Wylfa Newydd DCO Examination

Written Representation at Deadline 2 – Dafydd Griffiths

Shipping and navigation

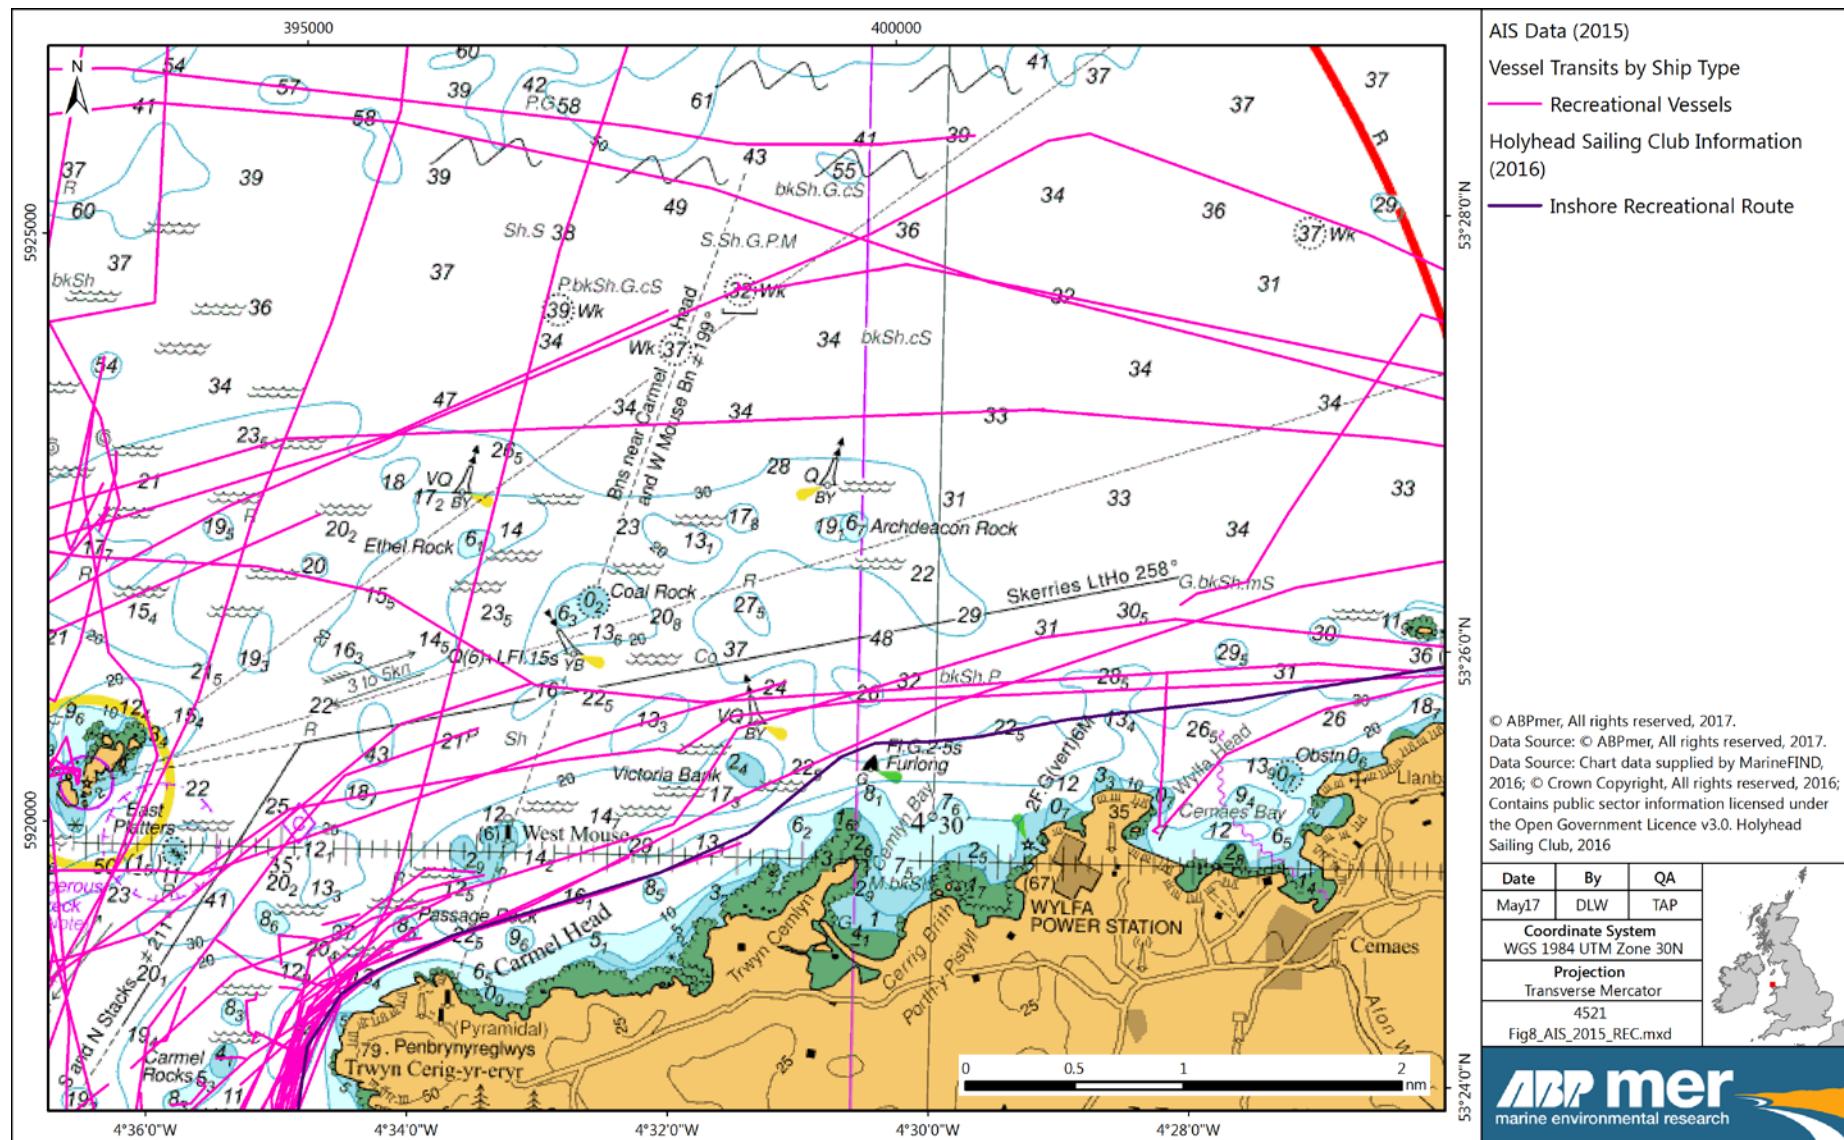
Figure 8. Recreational Transits through the Marine Works Area indicates the inshore recreational route that would be used by many smaller craft. This would be similar to my preferred route when sailing between Holyhead and Point Lynas. As noted in the Risk Assessment, whilst some of these smaller craft will have an AIS transceiver that both receives and transmits, a significant proportion will only have AIS receivers or no AIS at all. Could the applicant indicate the uplift that was used to take account of this when preparing the shipping and navigation assessment?

The final paragraph of the applicant's answer to Q5 above indicate that port service craft have not been considered as movements for the shipping and navigation assessments. As it is likely that the port service craft will rendezvous and release at a latitude and longitude near to or north of the popular inshore recreational route then I consider this may be a significant omission. In the context of Q5 the size of the vessel is irrelevant.
